**WELWYN HATFIELD BOROUGH COUNCIL  
EXECUTIVE DIRECTOR - PLANNING, PUBLIC PROTECTION AND GOVERNANCE**

**DELEGATED APPLICATION**

**Application No:** 6/2019/0754/VAR  
**Location:** Flats 15A-E, 15 Station Road, Cuffley, EN6 4HT  
**Proposal:** Variation of condition 8 (first & second floor northern elevation windows) and condition 10 (approved plans) on planning permission 6/2016/1857/VAR  
**Officer:** Mr David Elmore

6/2019/0754/VAR

drawn by	Stuart Hancock RIBA BSc (Hons) Architecture	
scale	1:100 @ A3	date 31 may 2016
dwg no	1/A100/CN/011	rev A12

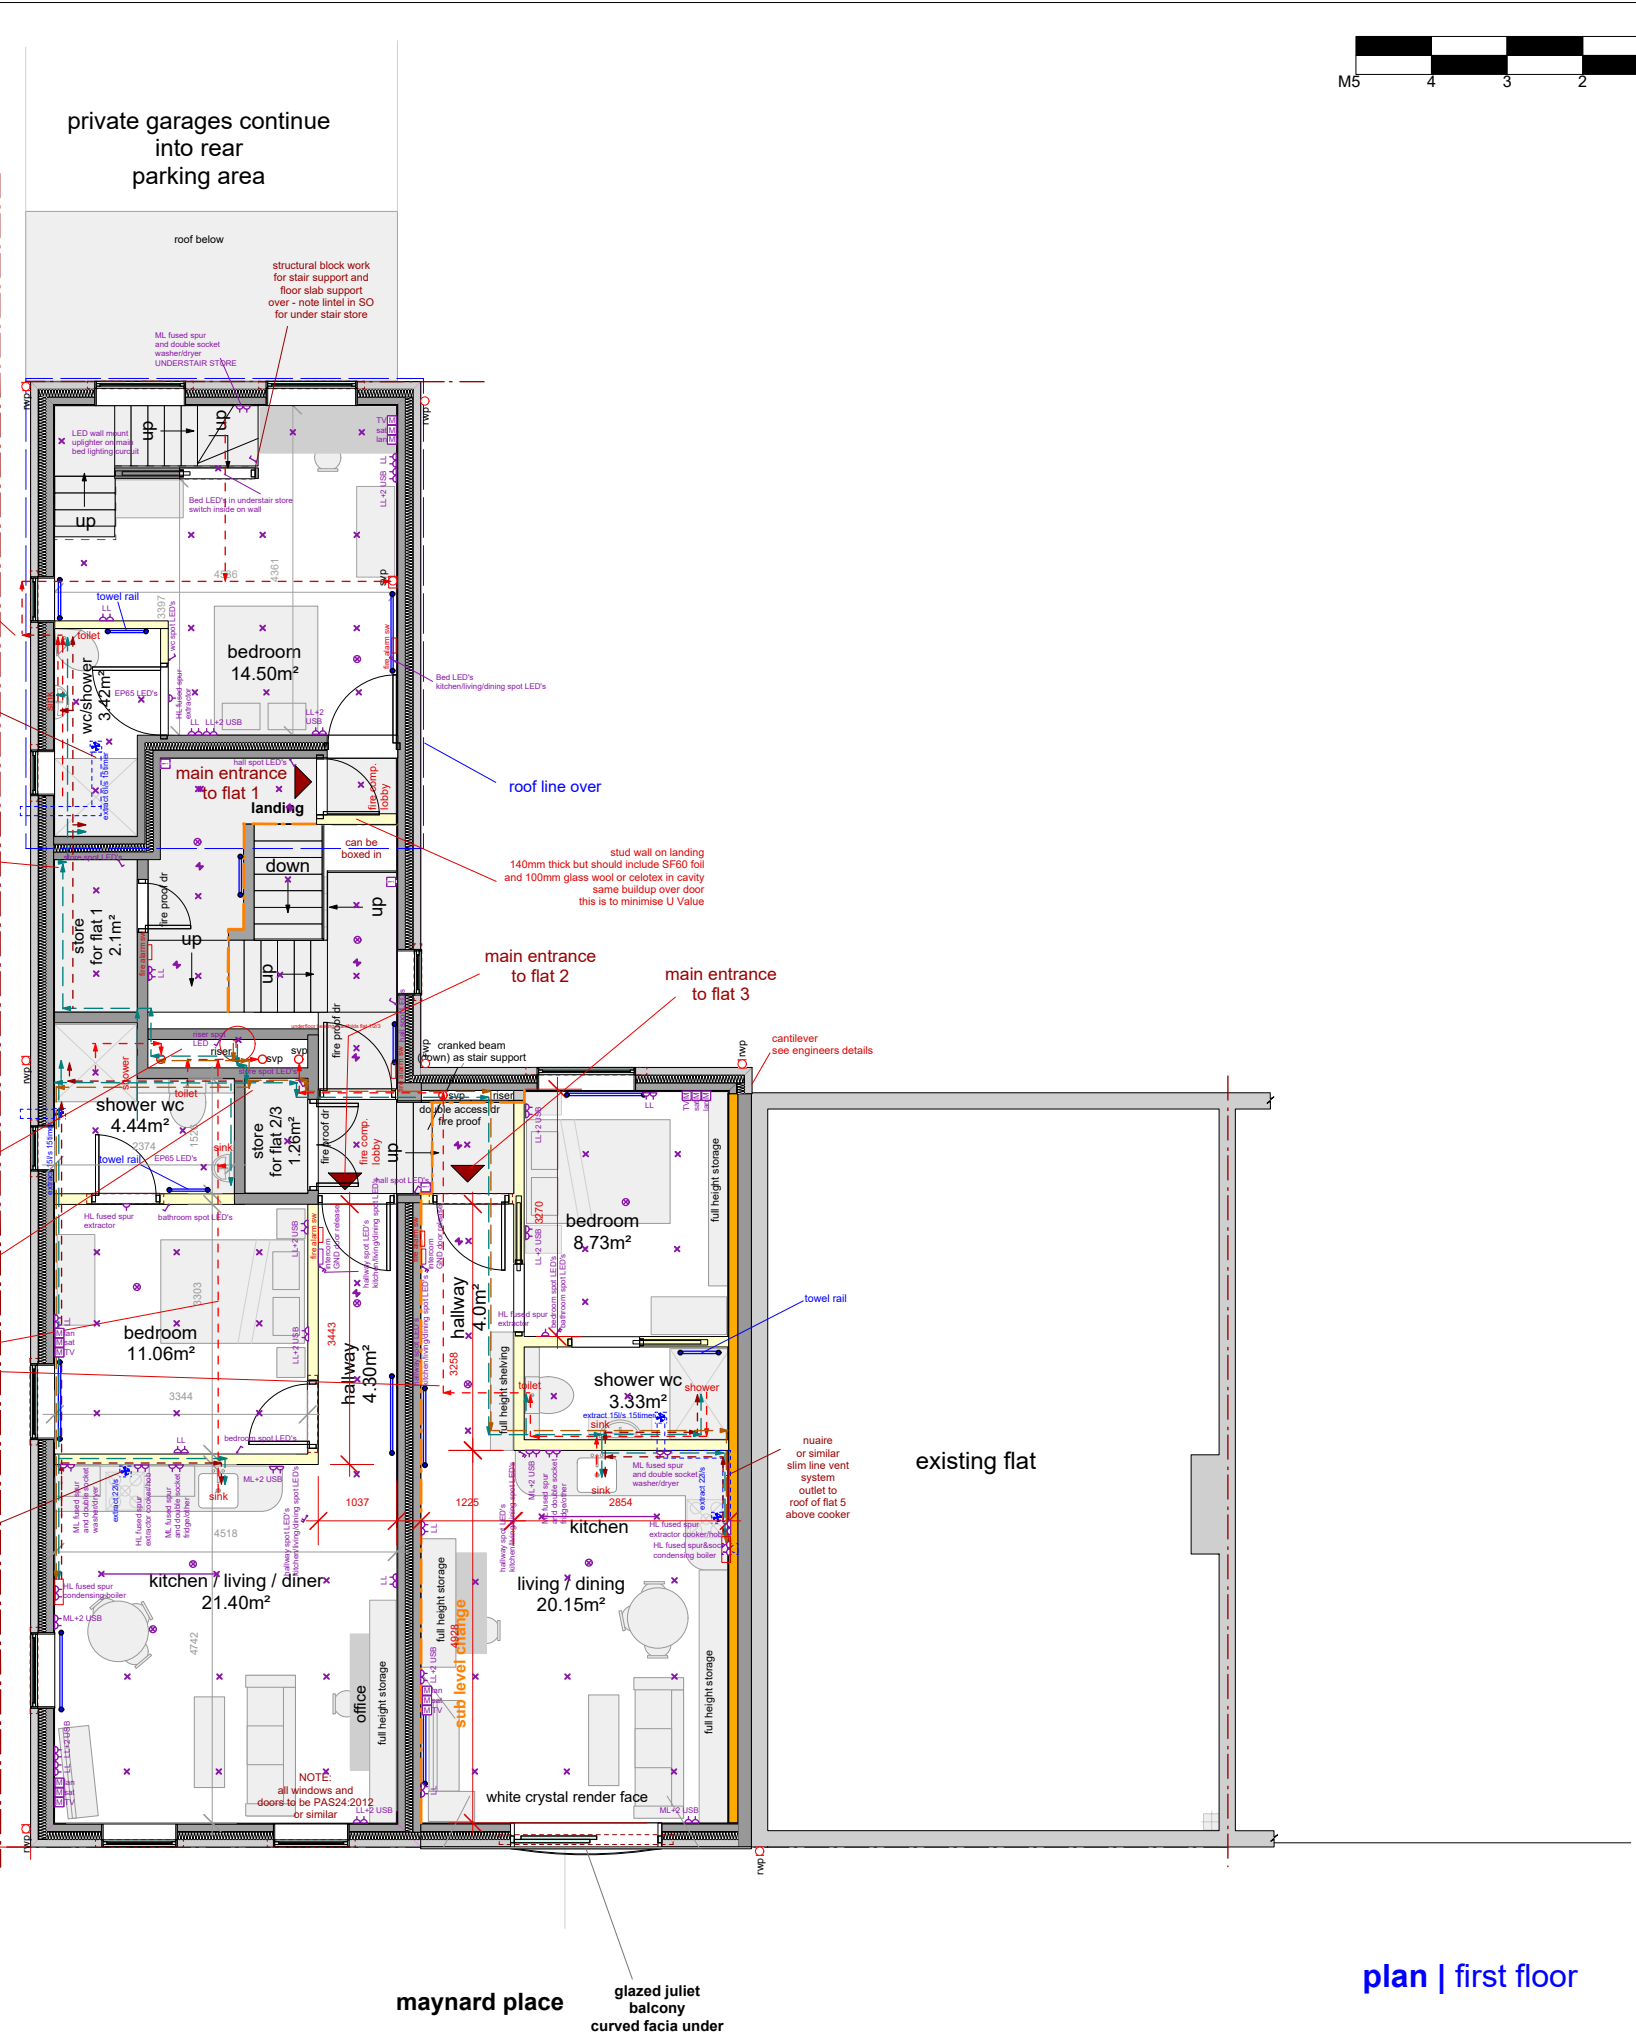
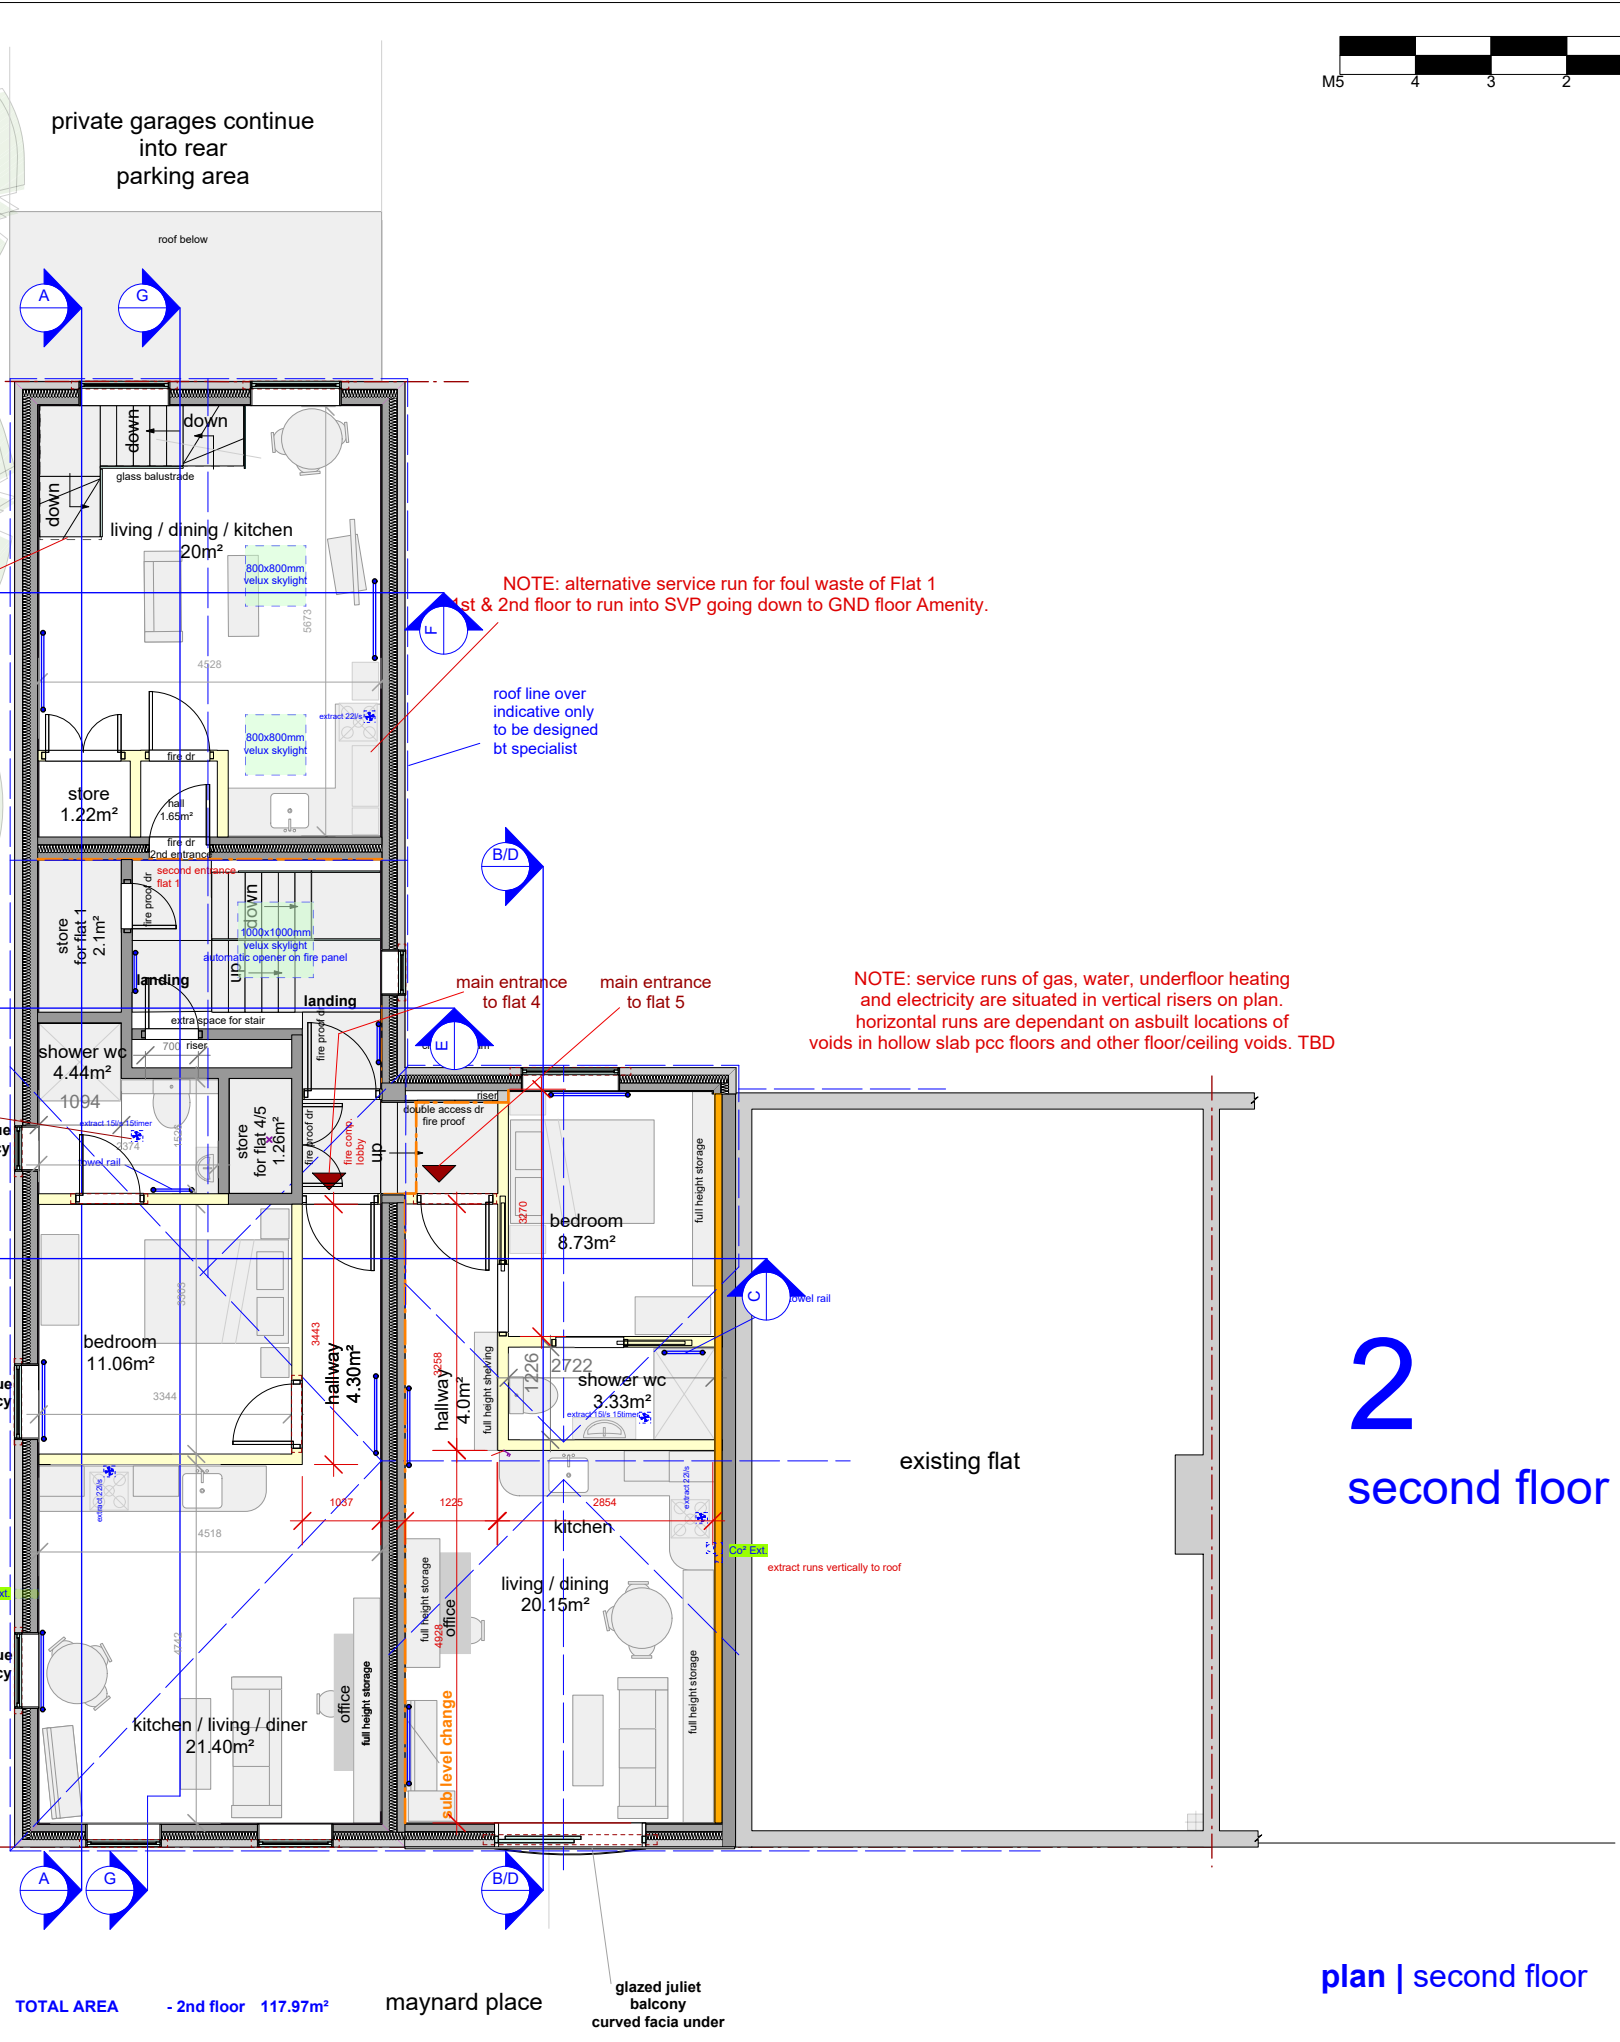
The alterations to the internal layout have involved re-configuration of certain flats and alterations to room sizes. No additional habitable accommodation or external openings have been created nor have the positioning of any approved external opening been changed. The internal alterations are insignificant and a satisfactory level of internal accommodation would be provided for its residents.

dwg no 0/A000/LP/011 rev A

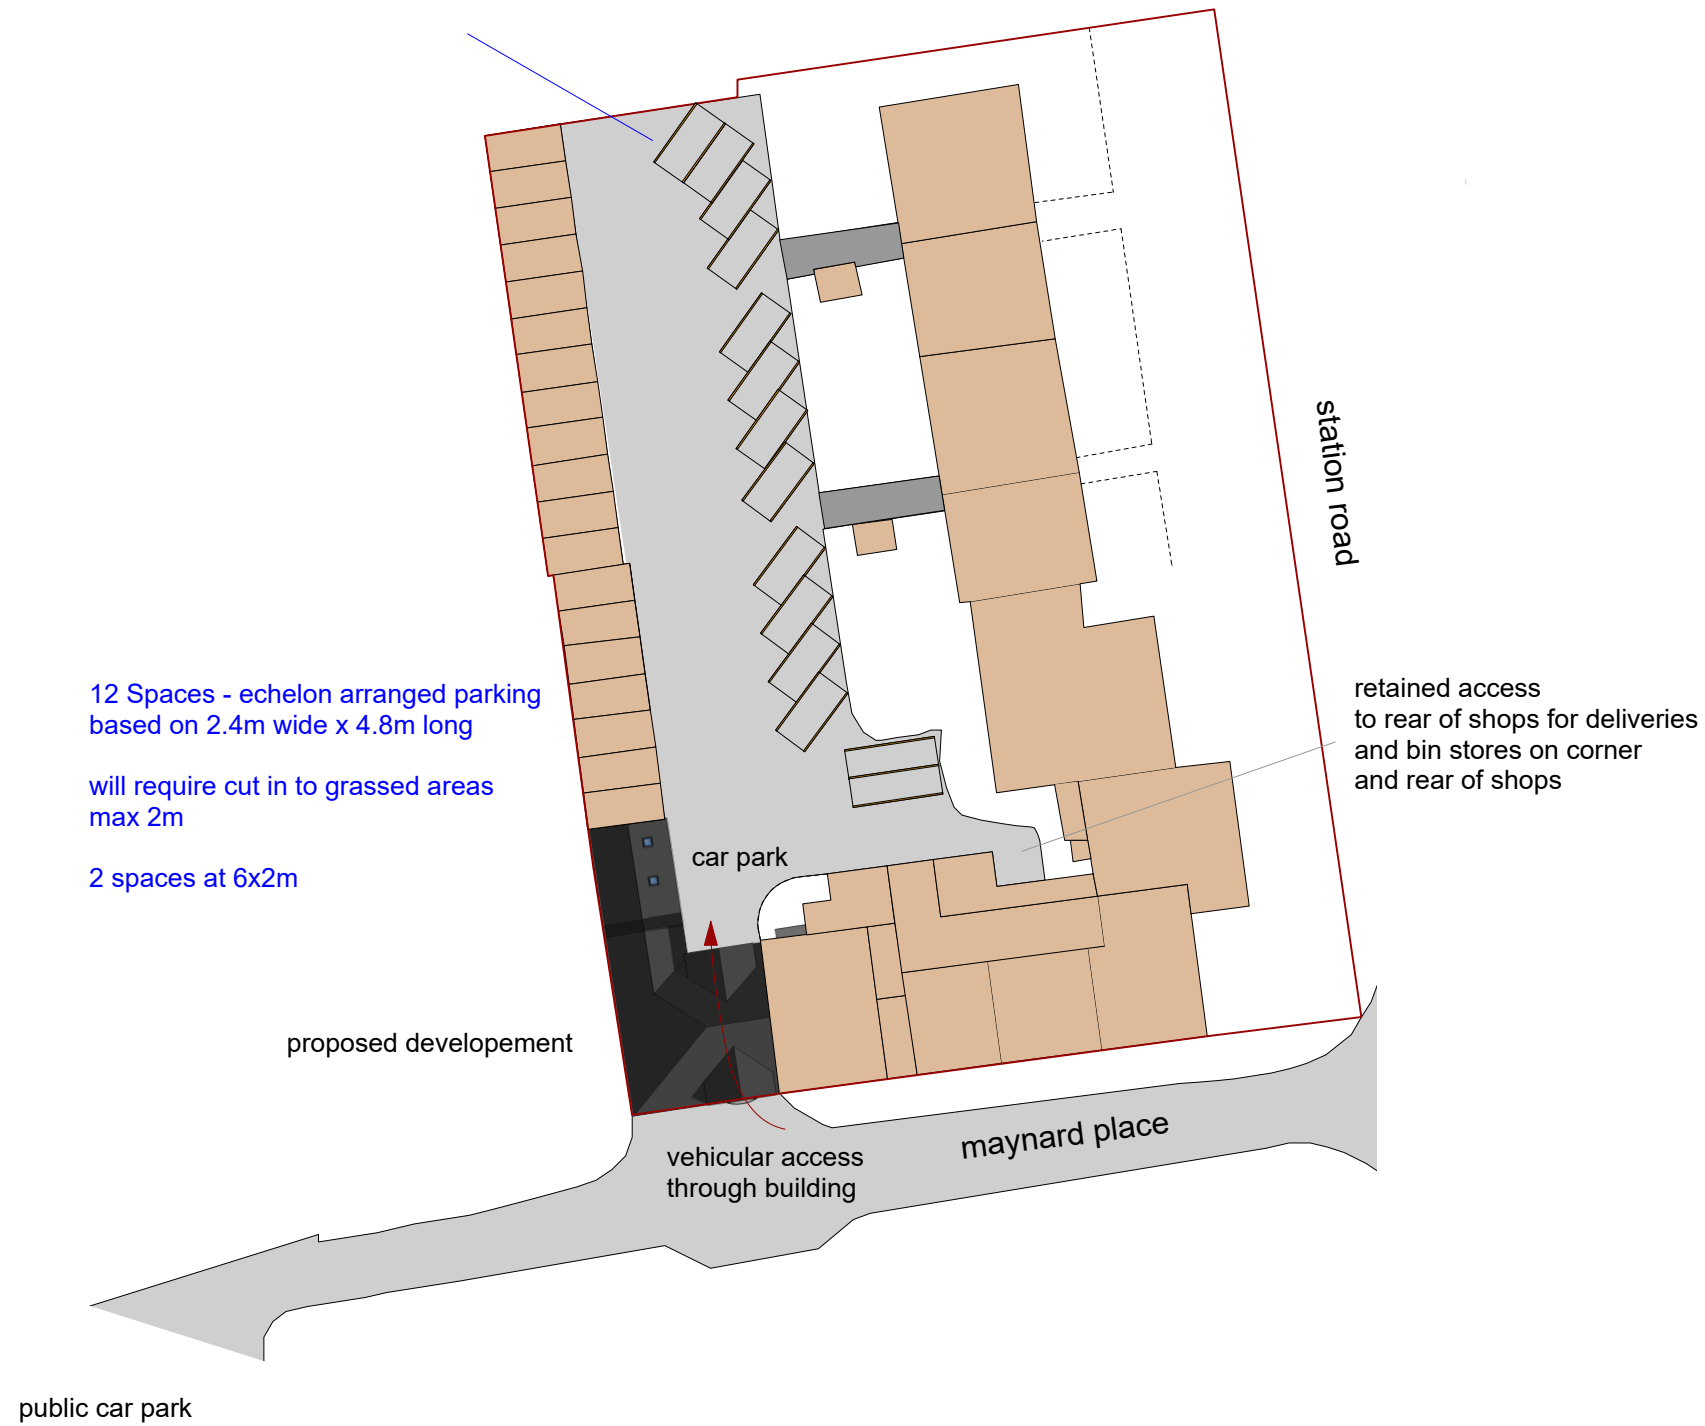
Condition 2 requires the approved hard-landscaping plan to be implemented and on-site parking to be laid out, demarcated, levelled, surfaced and drained. A site visit has confirmed that the on-site parking has not been laid or demarcated. Therefore, this condition will need to be reworded – setting a time limit for implementation, and imposed if this application were to be granted.

1. Within 3 months from the date of this decision notice, the on-site car parking areas must be laid out and demarcated in accordance drawing number: 0/A000/LP/011 Rev A, and must be retained permanently thereafter.
